EF13/5058, DOC17/333610-01
SSD 8114

SSD 8114 – LINDFIELD LEARNING VILLAGE – EIS

ATTACHMENT A
- ENVIRONMENT PROTECTION AUTHORITY COMMENTS -
LINDFIELD LEARNING VILLAGE EIS

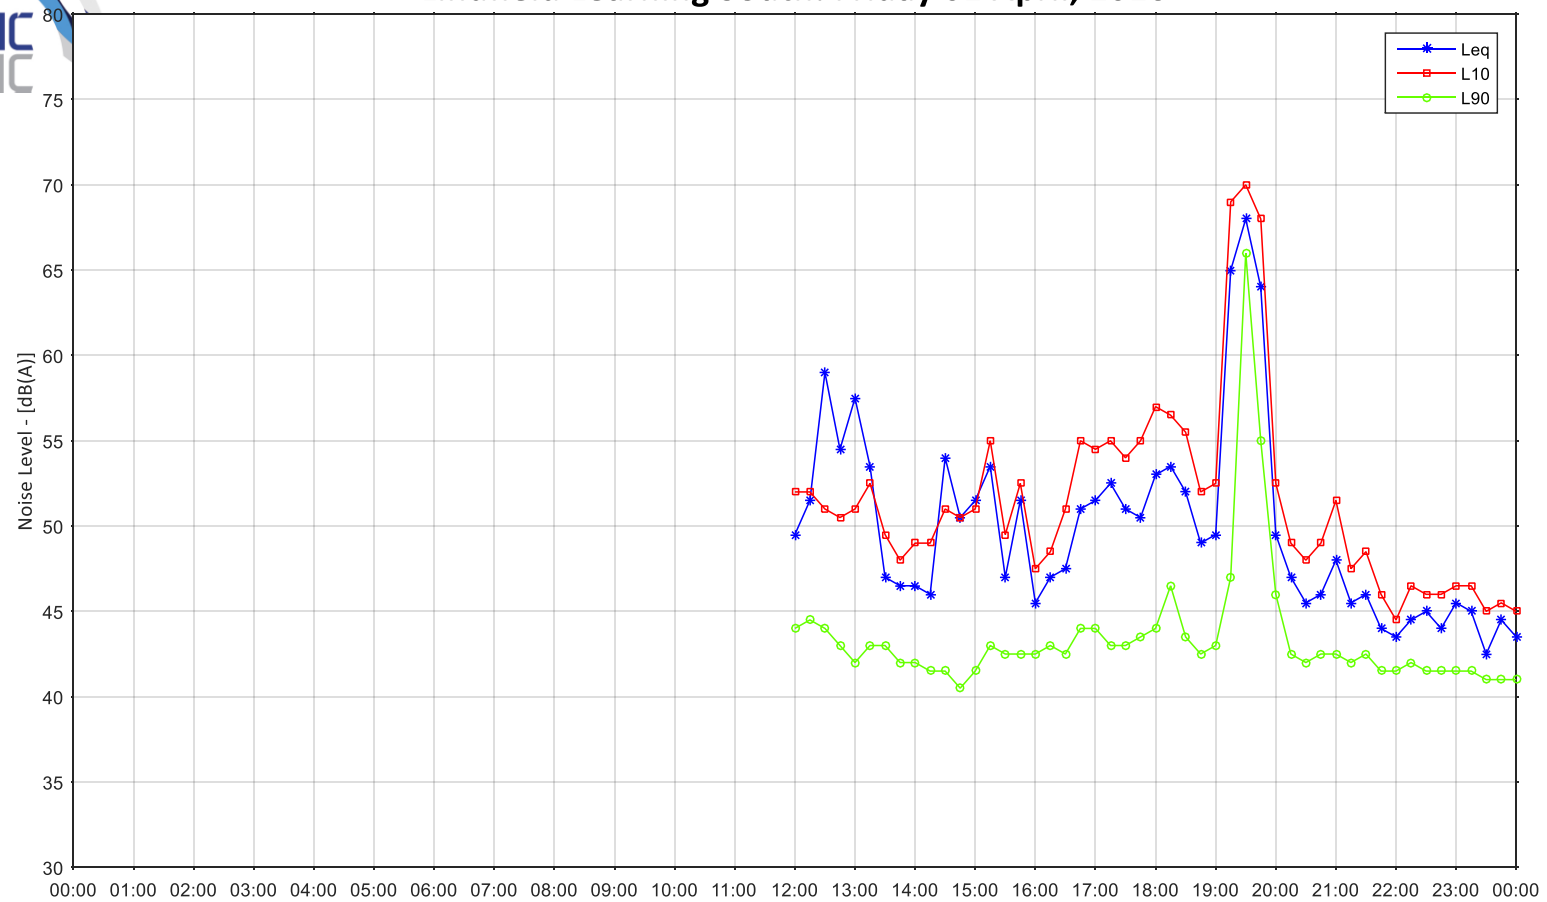
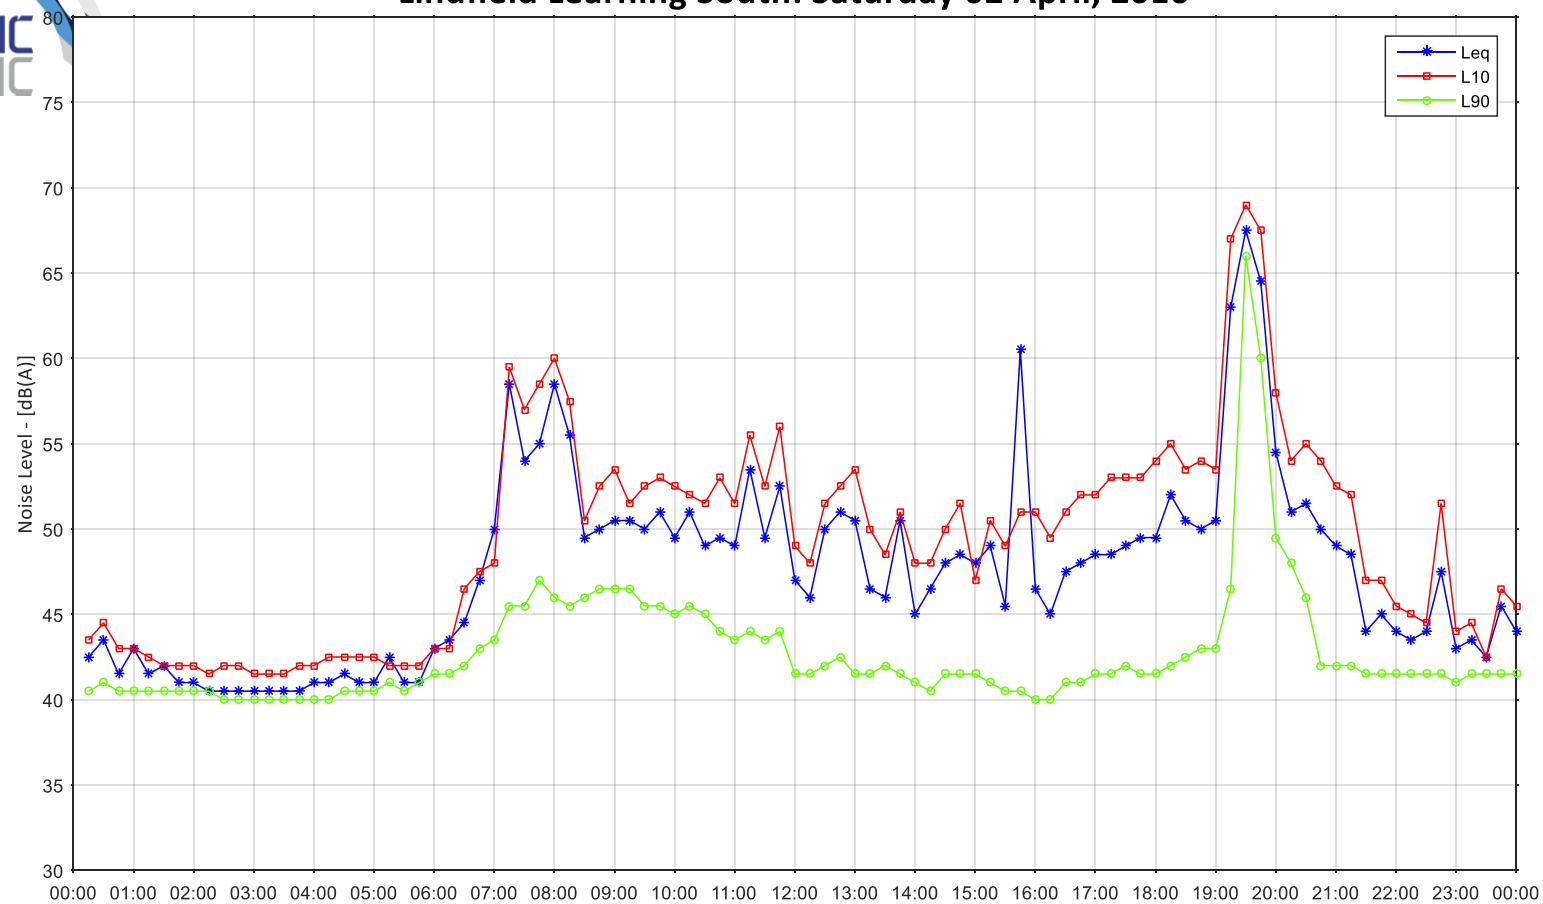
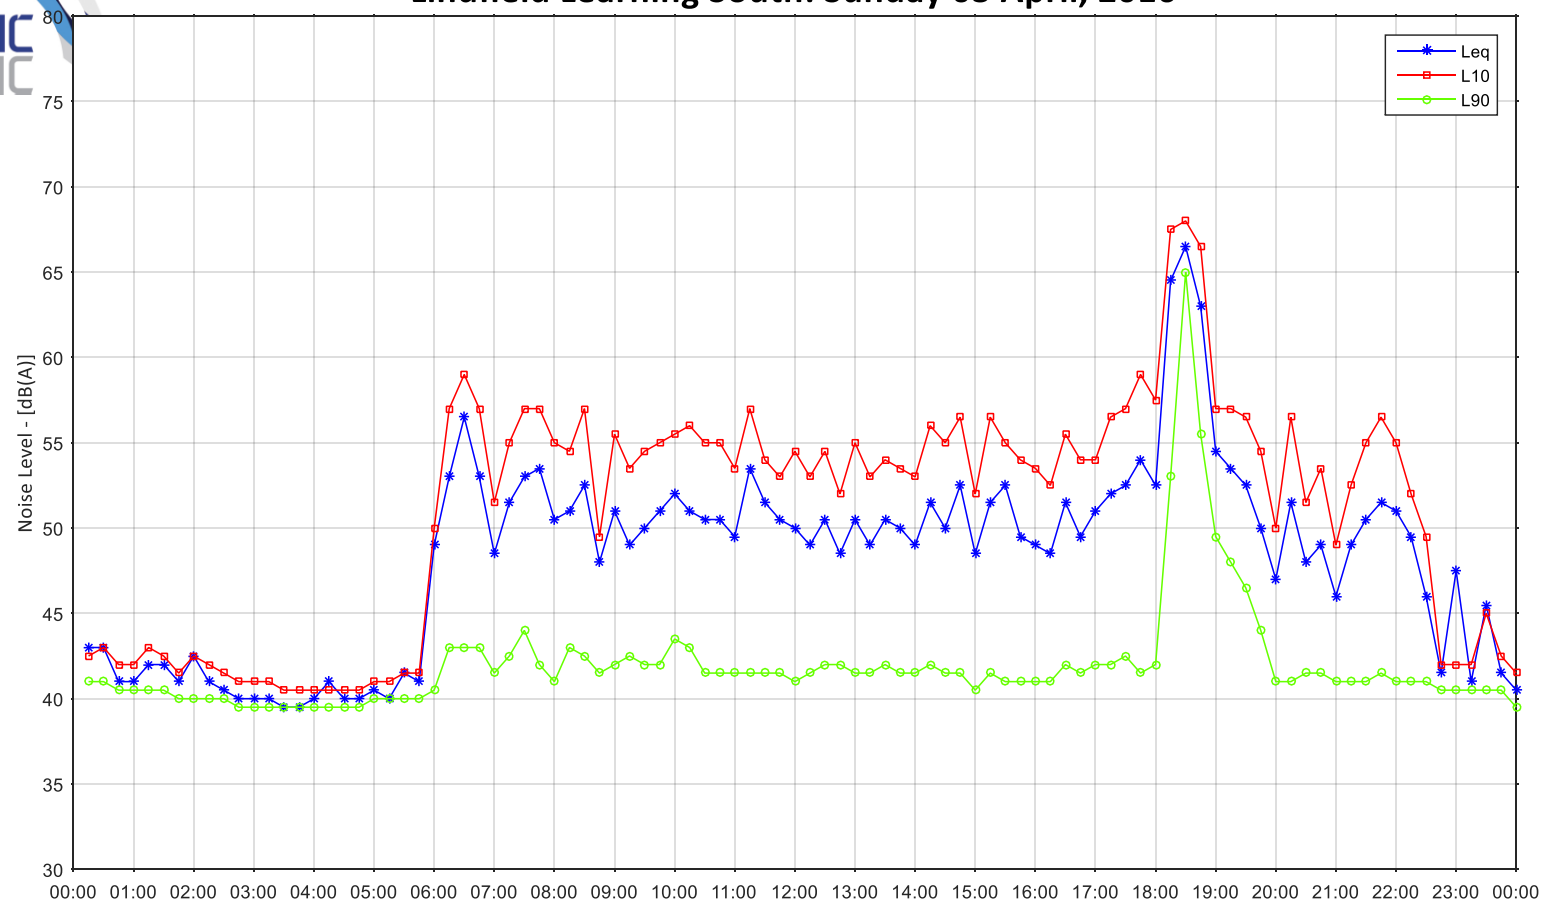
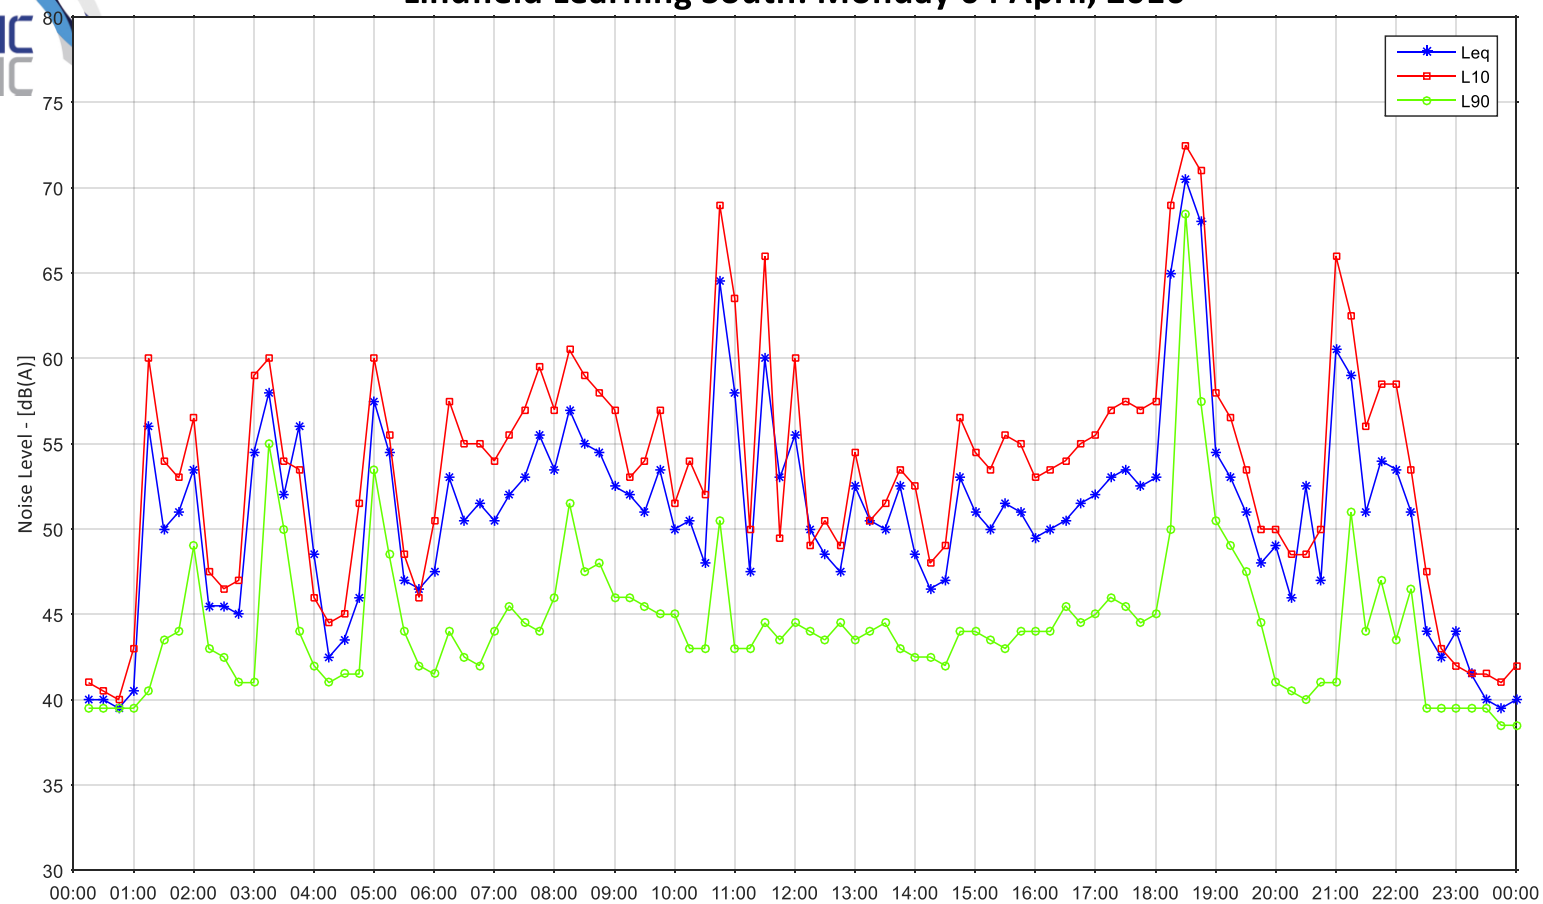
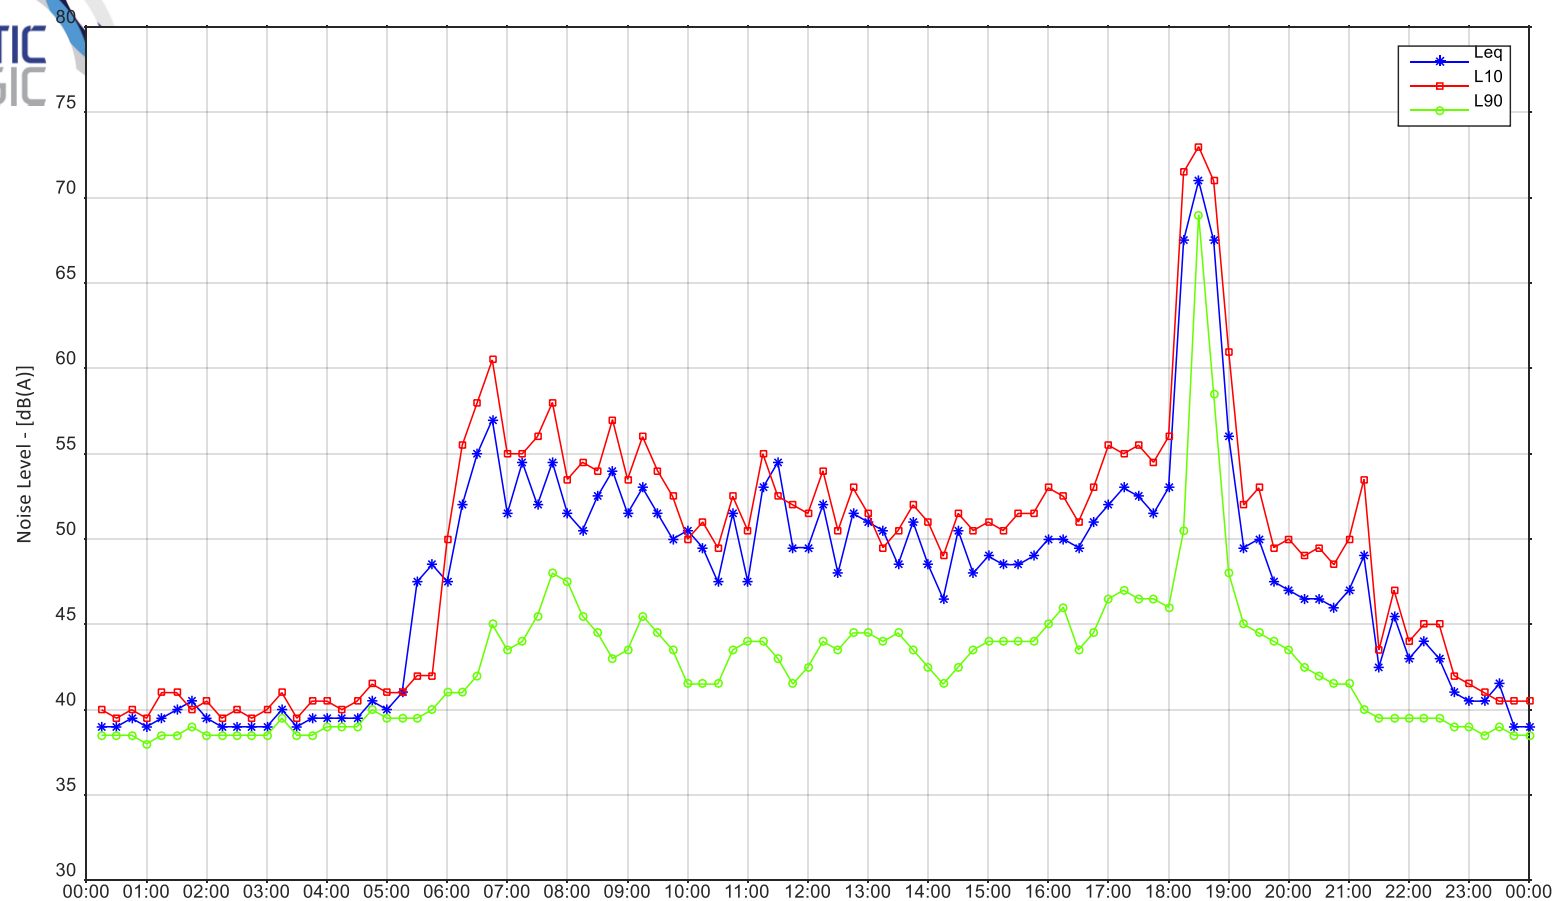
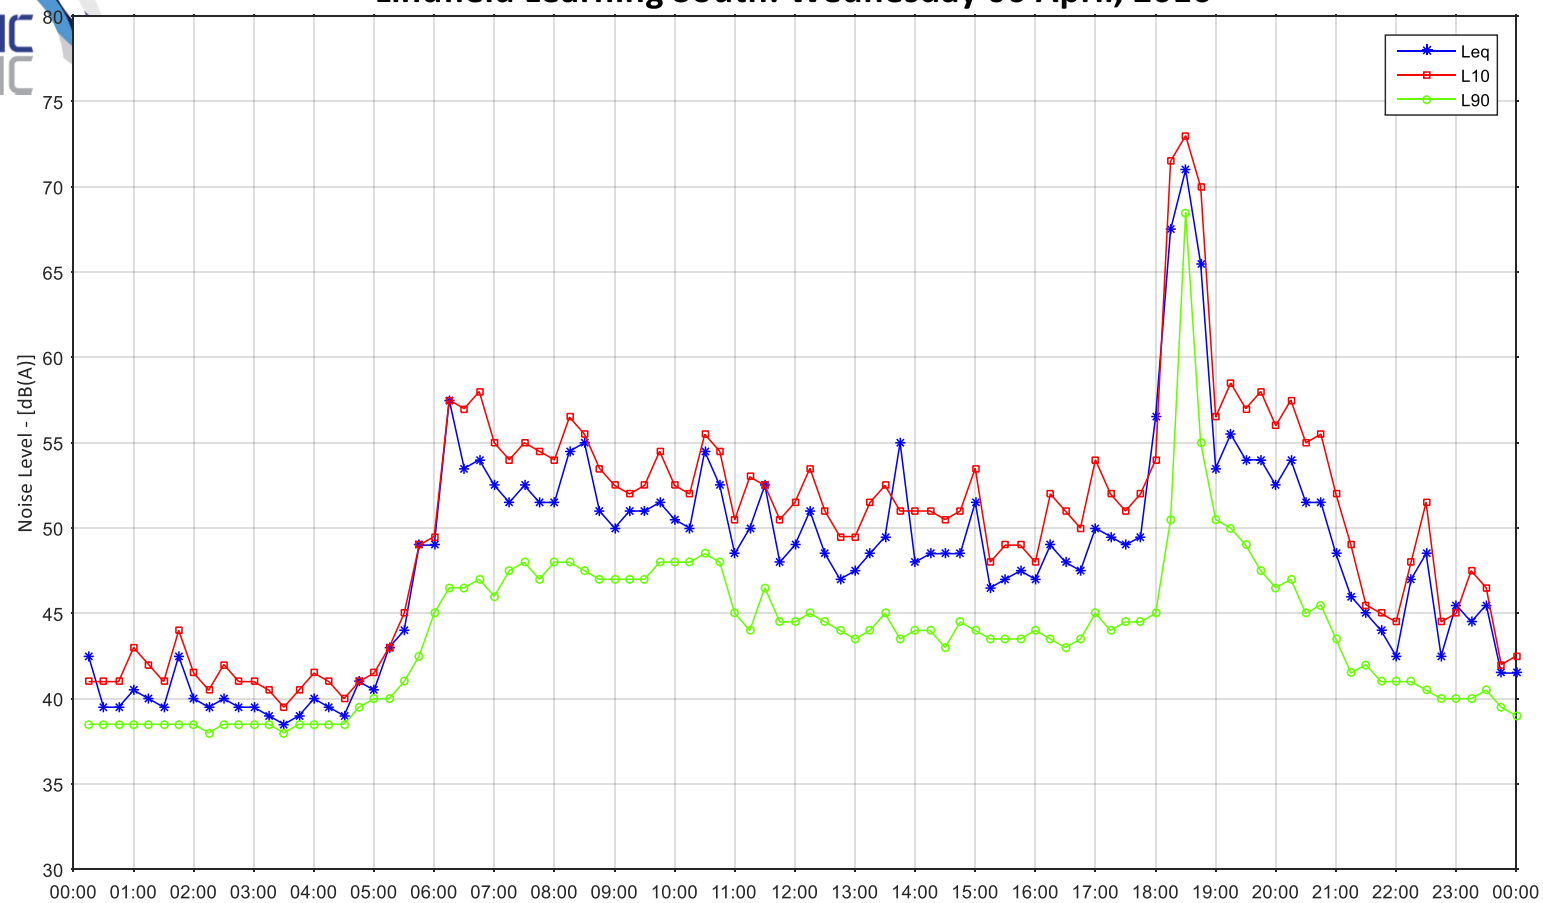
- (a) Table 1 to Appendix N presents day and evening period L_{A90} background noise levels for the South monitoring location as 48 dBA and 47 dBA respectively,
- (b) L_{A90} chart levels for the South location at the end of Appendix N show are lower than those levels presented in Table 1, typically around 40 dBA to 45 dBA,
- (c) Table 1 presents the $L_{Aeq(15hour)}$ level for the South location as 43 dBA which indicates that the background noise levels at that location are likely to be lower than those reported in Table 1.

The L_{Aeq} noise graphs attached to Appendix N show an unexplained noisy period (centred on about 6.30 pm) during the evening period on most nights and at both monitoring locations.

The proponent be required to explain the nature of the evening period noisy events represented by the peaks on the L_{Aeq} noise graphs approximately centred on 6.30 pm most nights during the background noise monitoring.

The proponent be required to review the background noise analysis and re-tabulate the Assessment Background Levels / Rating Background Levels for each monitoring location and time period (i.e. day, evening and night).
